16th August 2013

Application for Planning Permission for Works or Extension to a Dwelling

Development Single storey rear conservatory

Location 1 Abercorn Walk Eastergate

SITE PLAN 1:500

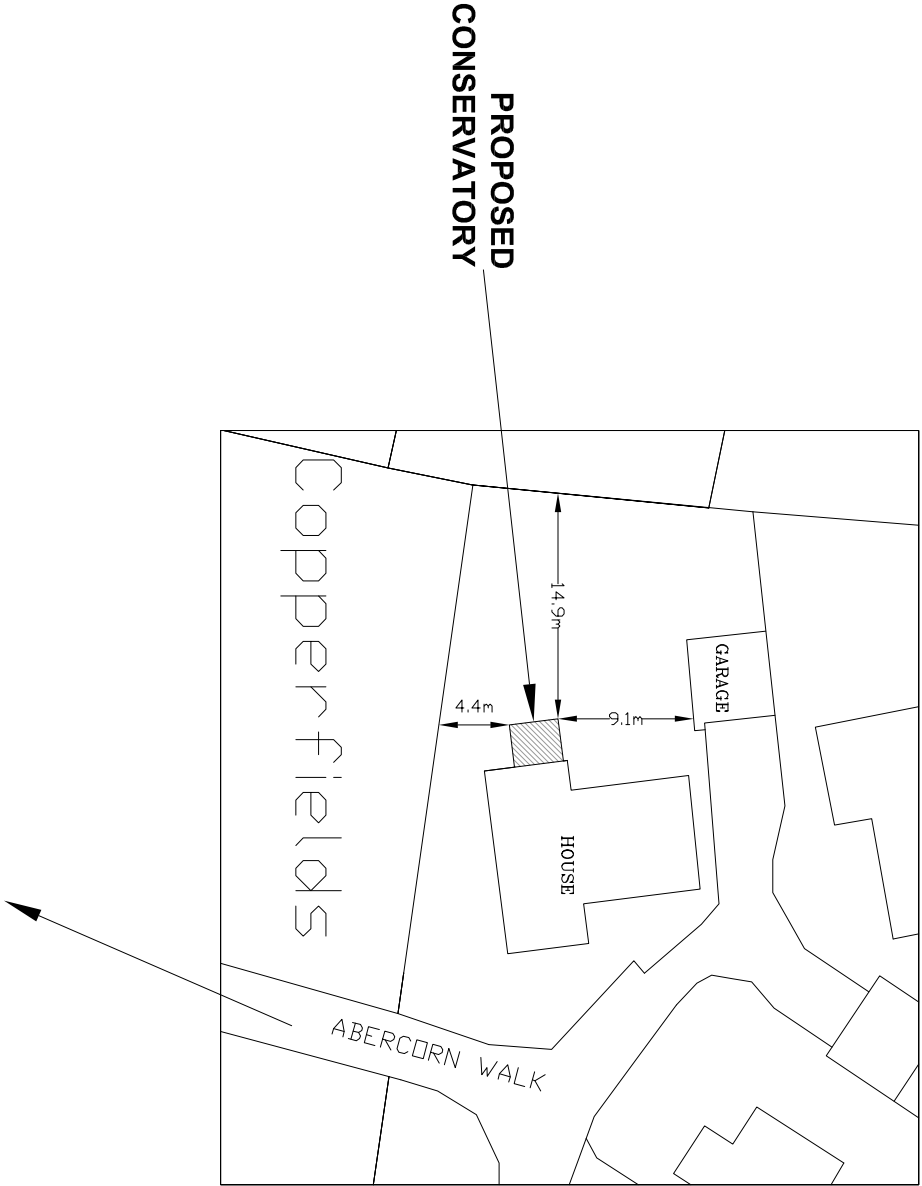
Block Plan

Please submit 1 electronic or 3 paper copies of a block/site plan at a scale of 1:500 or 1:200. Further details of what must be included on the plan can be found in the National Validation Requirements. Please provide one named road and the measurements of the proposal to each boundary on the site.
